# City of Albuquerque

September 10, 1993

RE: GRADING PLAN FOR TRAILS @ SEVEN BAR SOUTH - PHASE 1 (B-13/D6A)  
CITY PROJECT NO. 4727.90  
RECEIVED AUGUST 20, 1993, ENGINEER'S STAMP DATED 8-19-93  
FOR ROUGH GRADING PERMIT APPROVAL

THE TRAILS AT SEVEN BAR SOUTH TRACT K BORROW GRADING PLAN

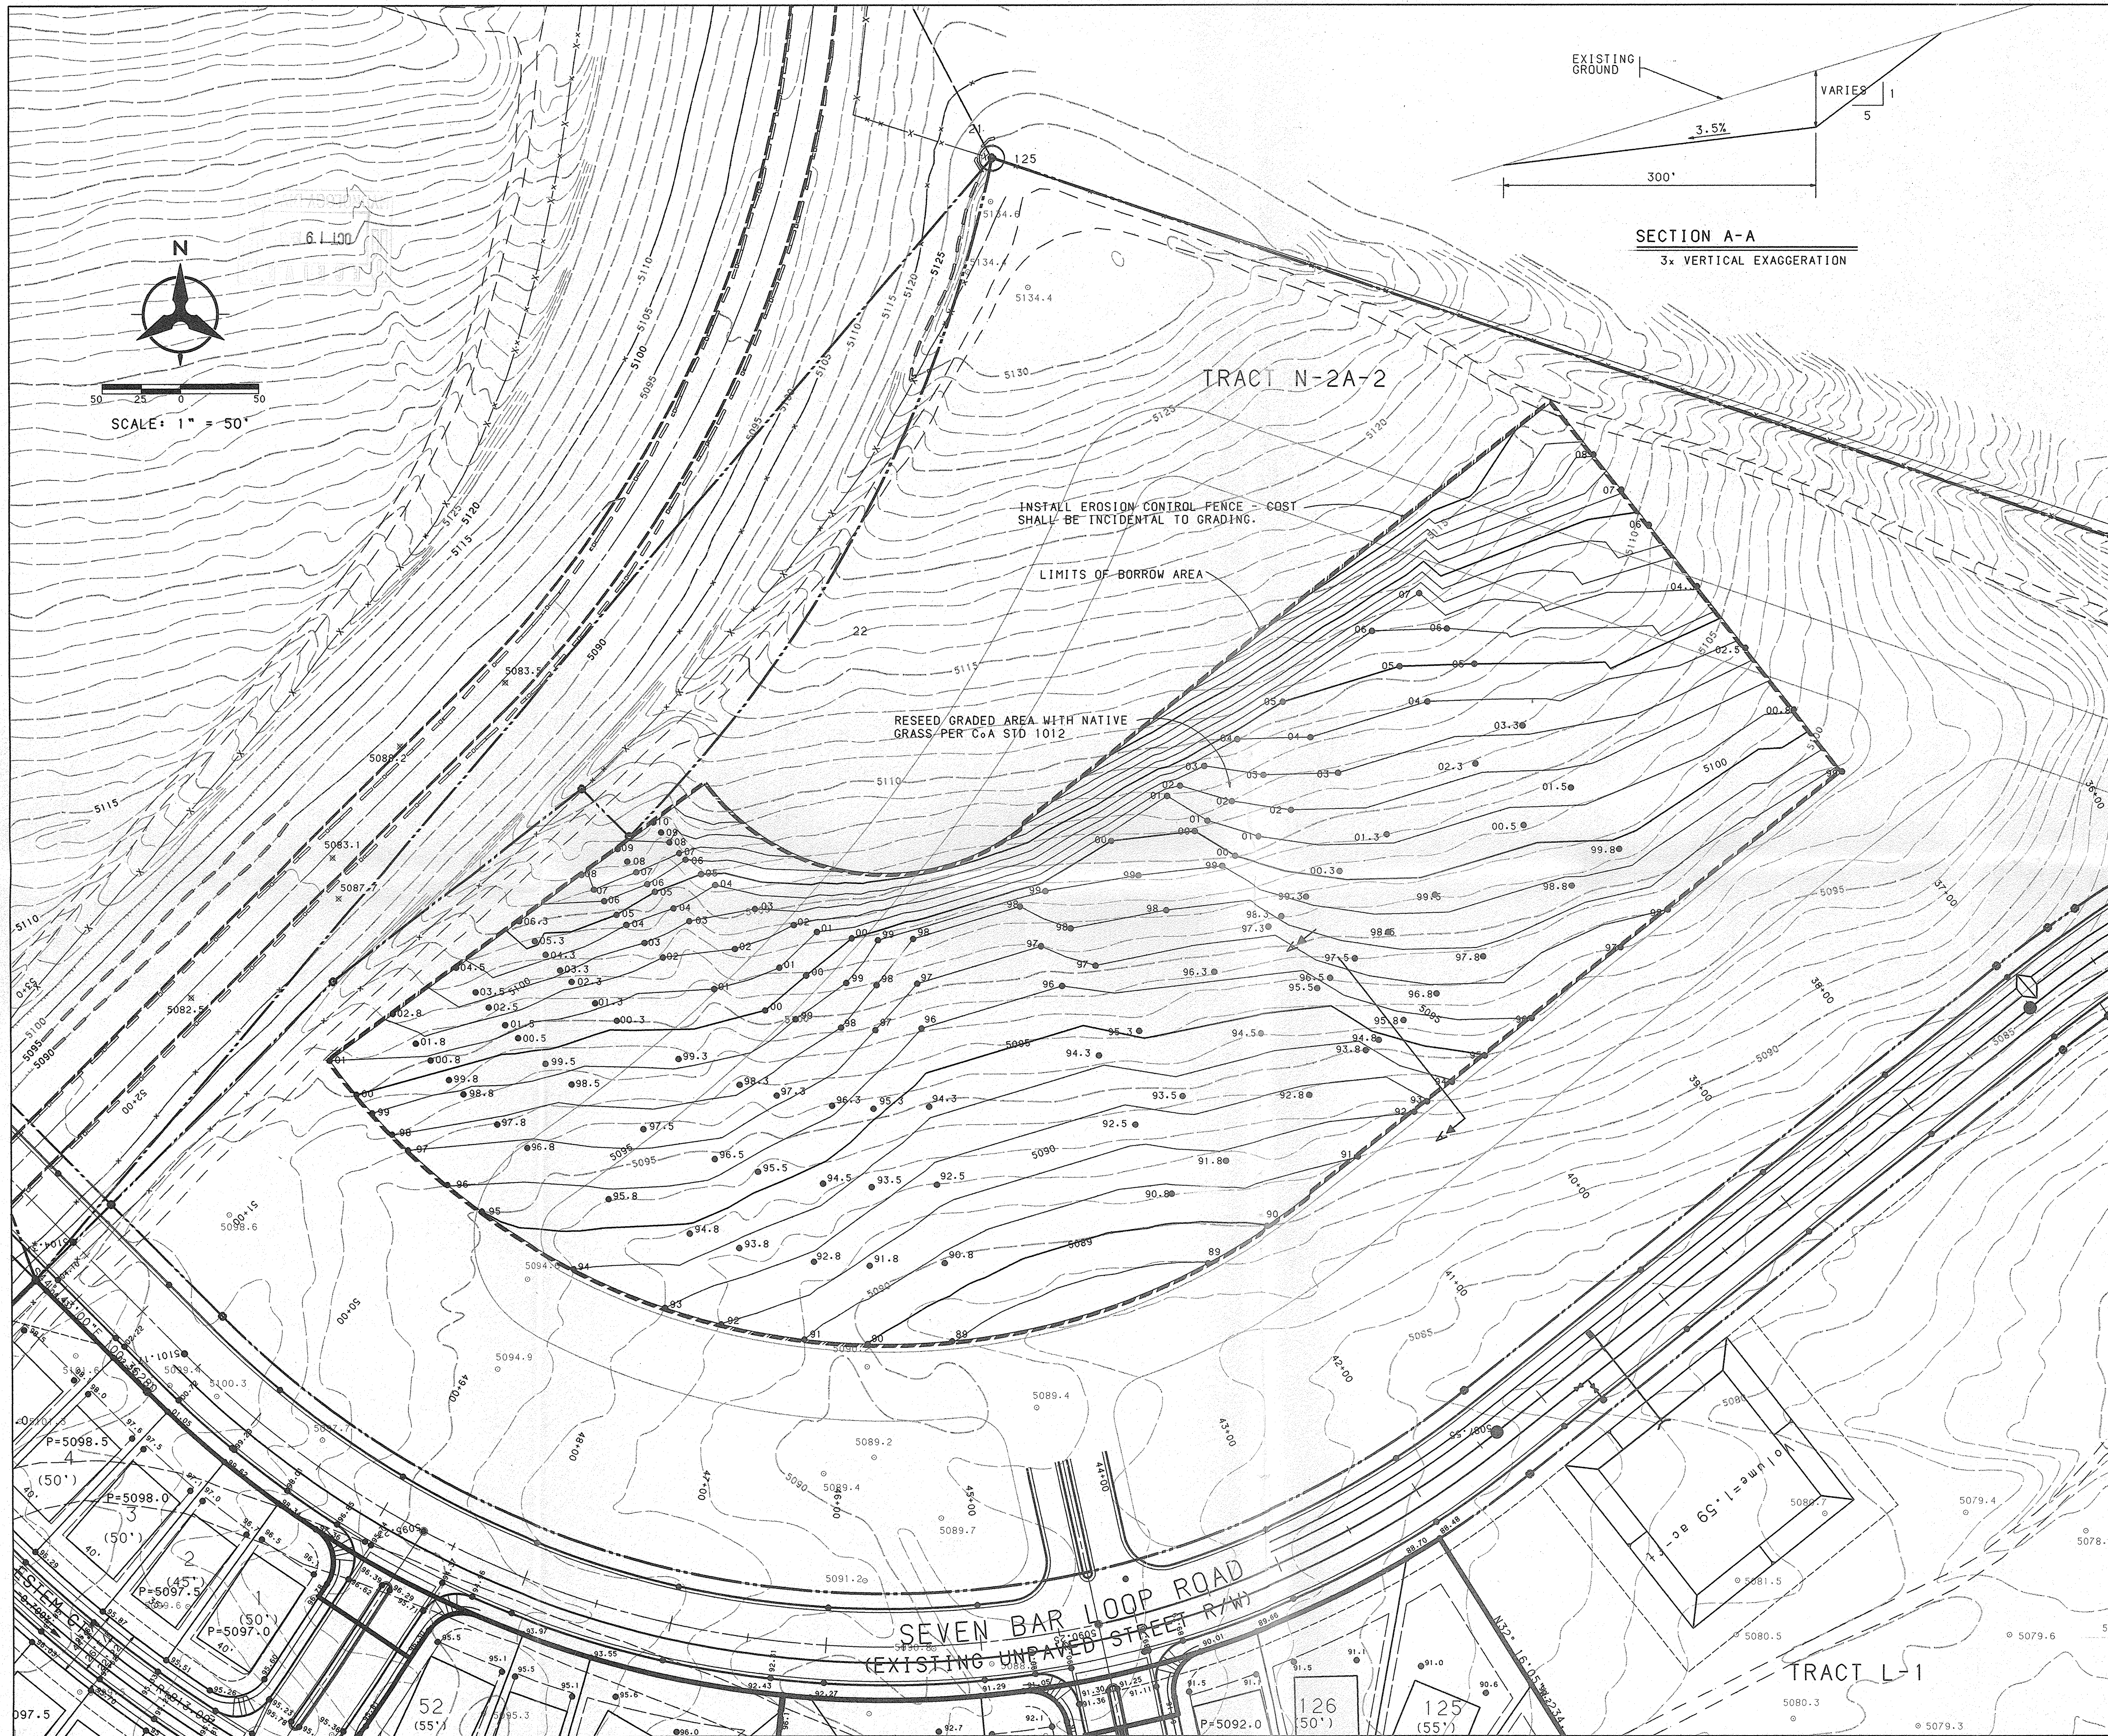
Based on the information included in the submittal referenced above, City Hydrology APPROVES the Phase I Borrow Site and REJECTS the Tract K Borrow Grading Plan.

Any grading on Tract K must be approved by the Public Housing Services in writing. Any submittal concerning Tract K must include a copy of the approval letter from the Public Housing Services.
